Date: 24-Dec-2024
Our Ref: 2024/91495

**Application for a non-material amendment following a grant of planning permission,
Town and Country Planning Act 1990**

**Non material amendment to previous permission 2024/90120 for erection of single
storey side extension with associated internal and external works
16, Dearne Park, Clayton West, Huddersfield, HD8 9NB
Application Number: 2024/91495**

AW_001 V1

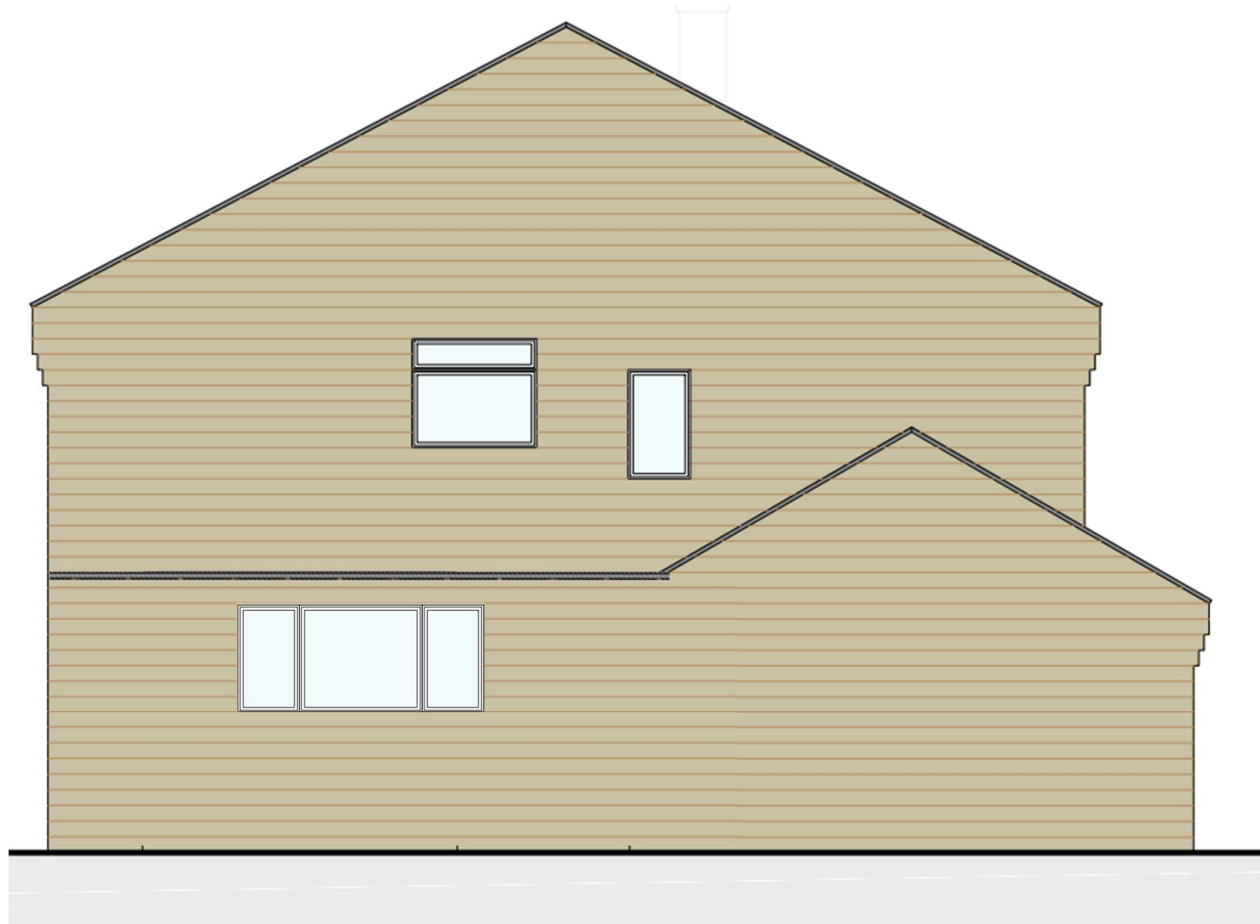
Thank you for your application dated 28-May-2024 for a non-material amendment to the above scheme. The amendment sought is the change from a pitched roof to a flat roof which would see a reduction in the roof height of approximately 1.3m. The flat roof feature would span approximately 5.8m along the side (west) elevation of the proposal.

I confirm that the alterations are acceptable and may be considered as a non-material amendment to the approved drawings. It should be noted that this letter relates only to the non-material amendment sought and it is not a re-issue of the original planning permission. The two documents should be read together and as such, all conditions imposed on the original granting of planning permission apply to the proposal as now amended. A copy of this letter and the amended plans will be retained on the public record of approved documents.
